CITY OF PORTLAND, MAINE

PLANNING BOARD

RE: Proposed Ballpark Drive Subdivision
ID #2004-0028, CBL #371 A002001

On September 21, 2004 the Portland Planning Board voted unanimously (6-0, Patterson absent) to approve the Ballpark Drive Subdivision in the vicinity of Washington Avenue and Riverside Street, with the following conditions:

SHEET TITLE:	BALLPARK DRIVE ENTRANCE PEDESTRIAN IMPROVEMENTS	SHEET 10 OF 10
SCALE:	AS SHOWN	DRAWING NO.:
DATE:	SEPTEMBER 3, 2004	10

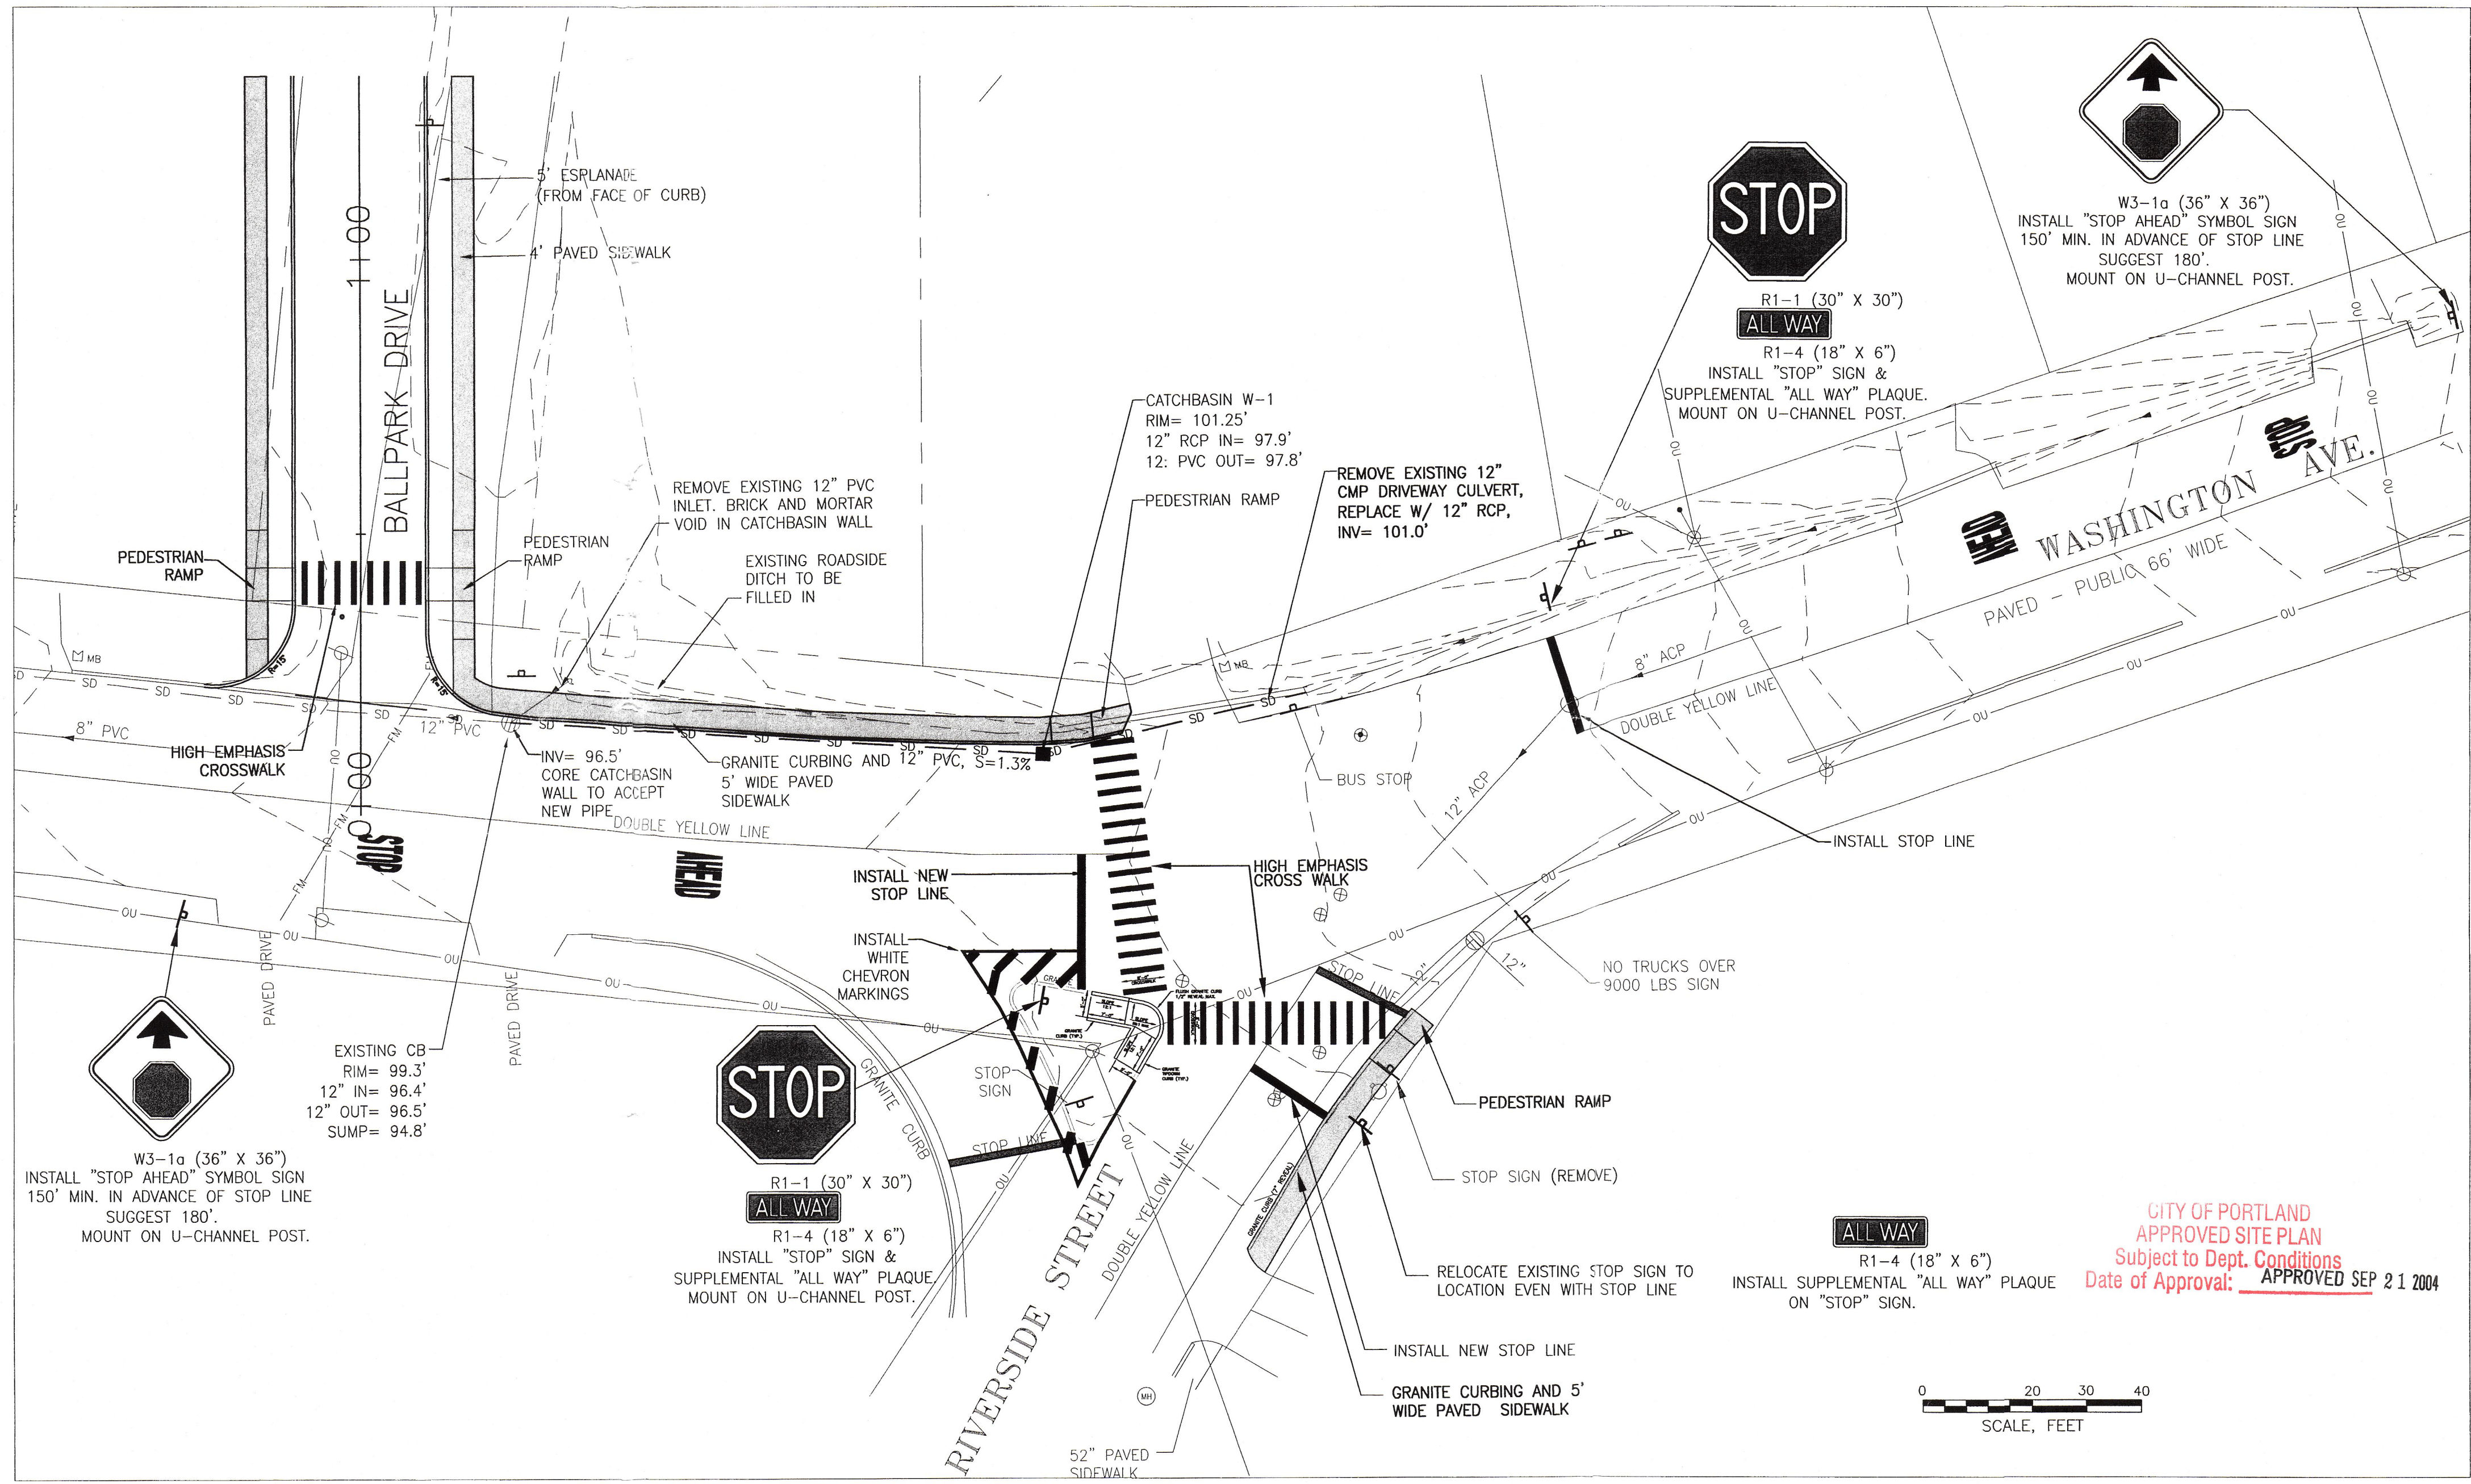
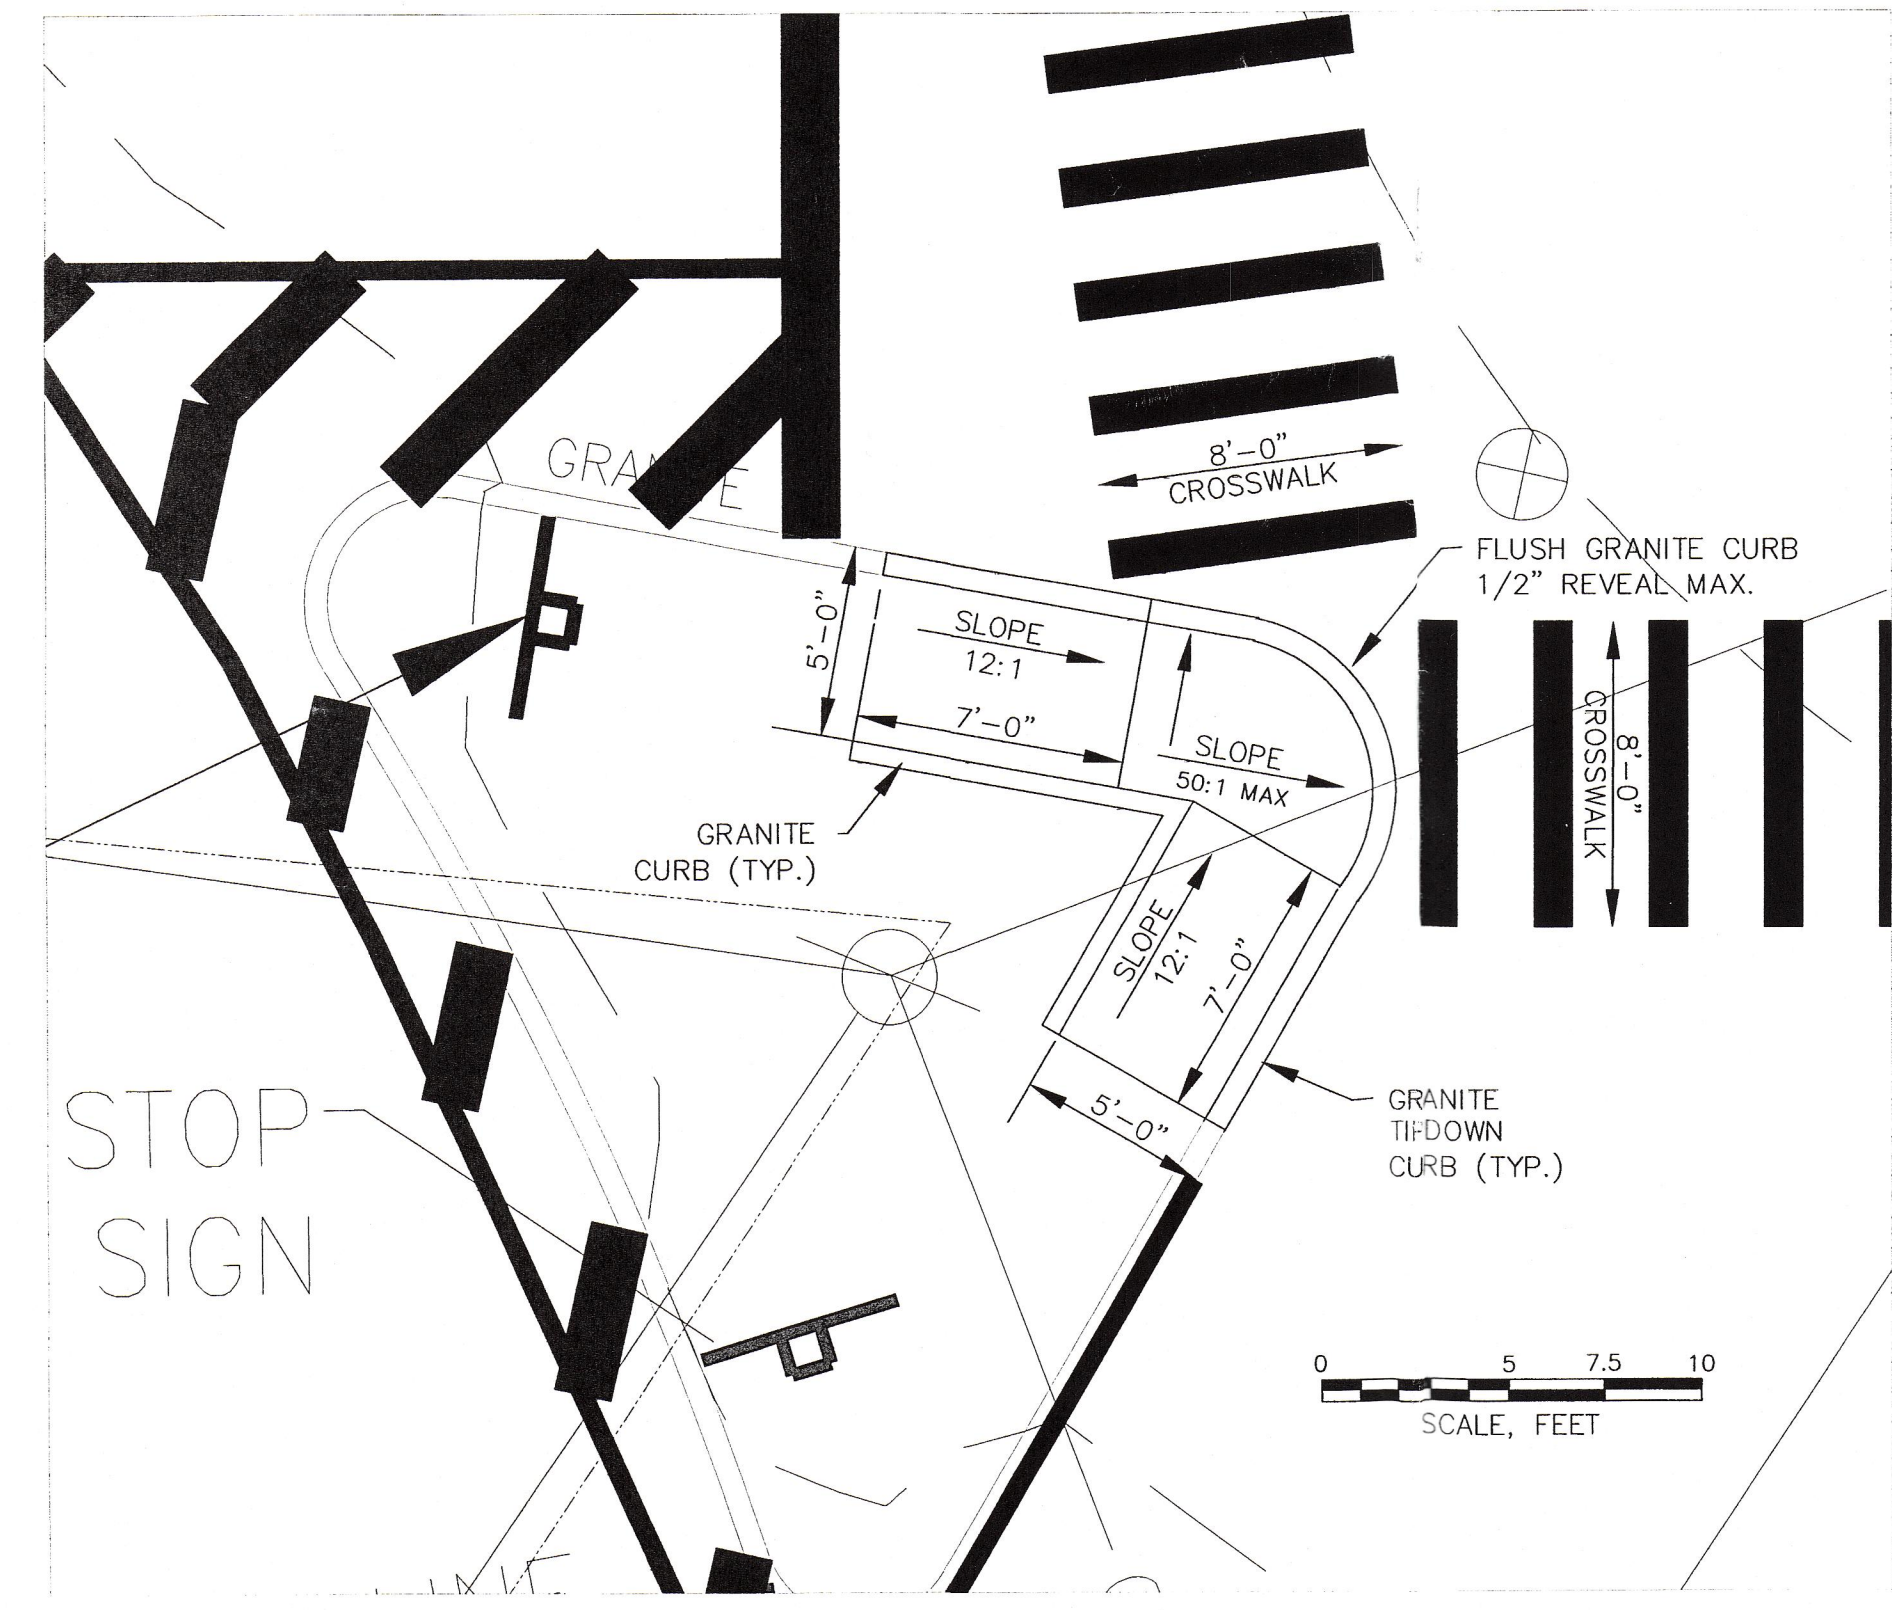
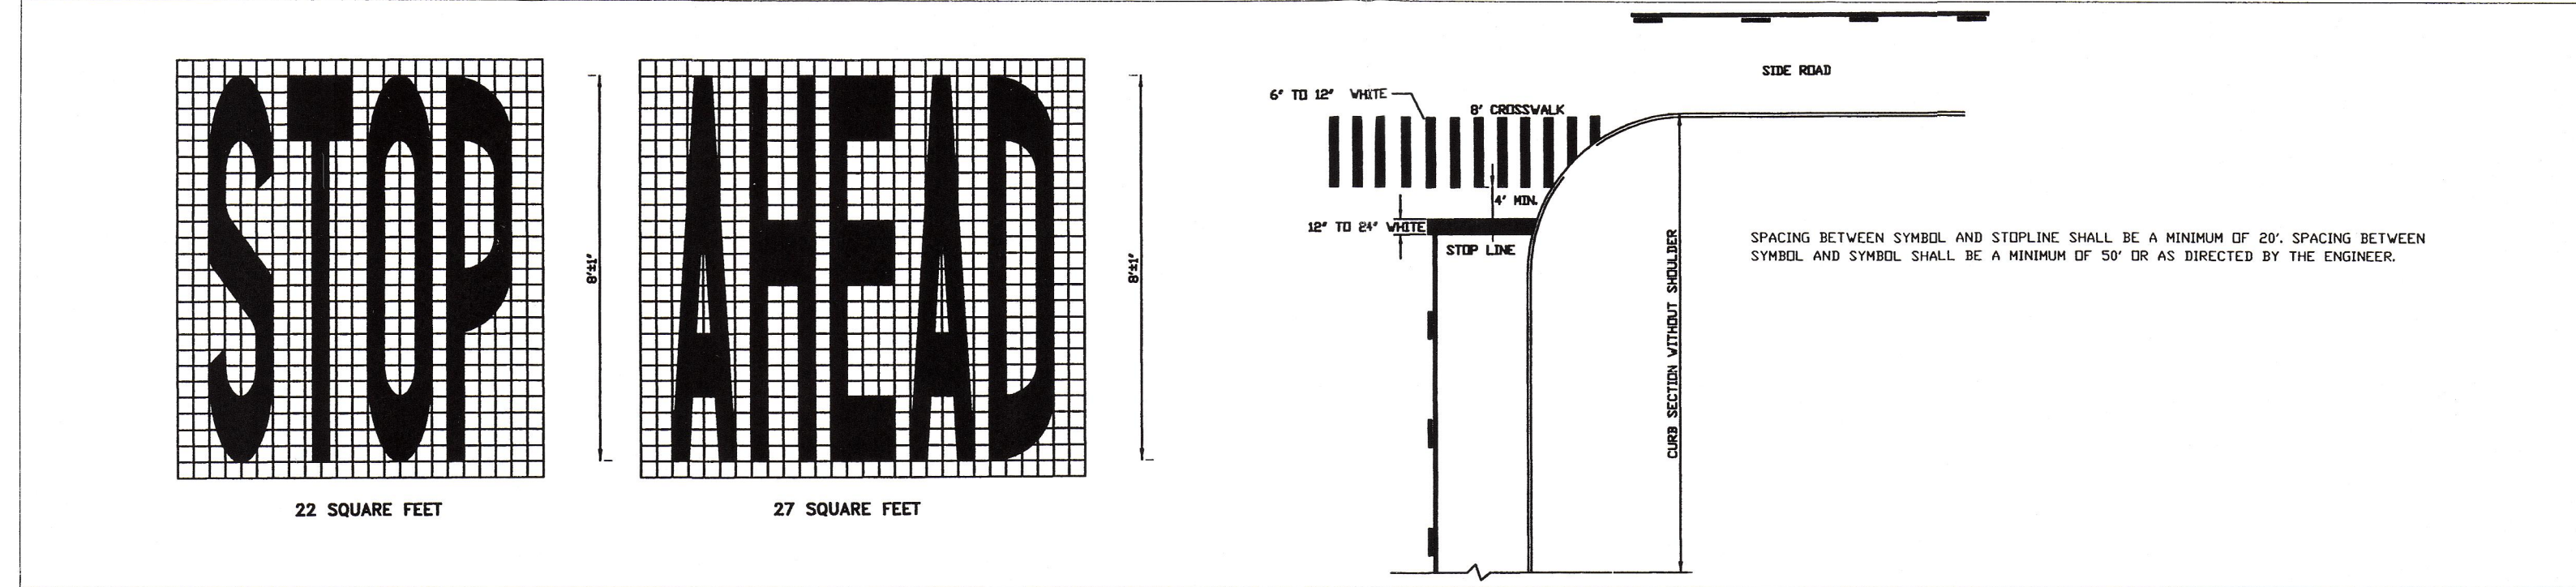
- iv. The proposed street tree installation plan shall be subject to final review and approval by the City Arborist and the Planning Authority.
- v. The proposed improvements to the Washington Avenue / Riverside Street and Washington Avenue / Ballpark Drive intersections shall be subject to final review and approval by the City's traffic division.
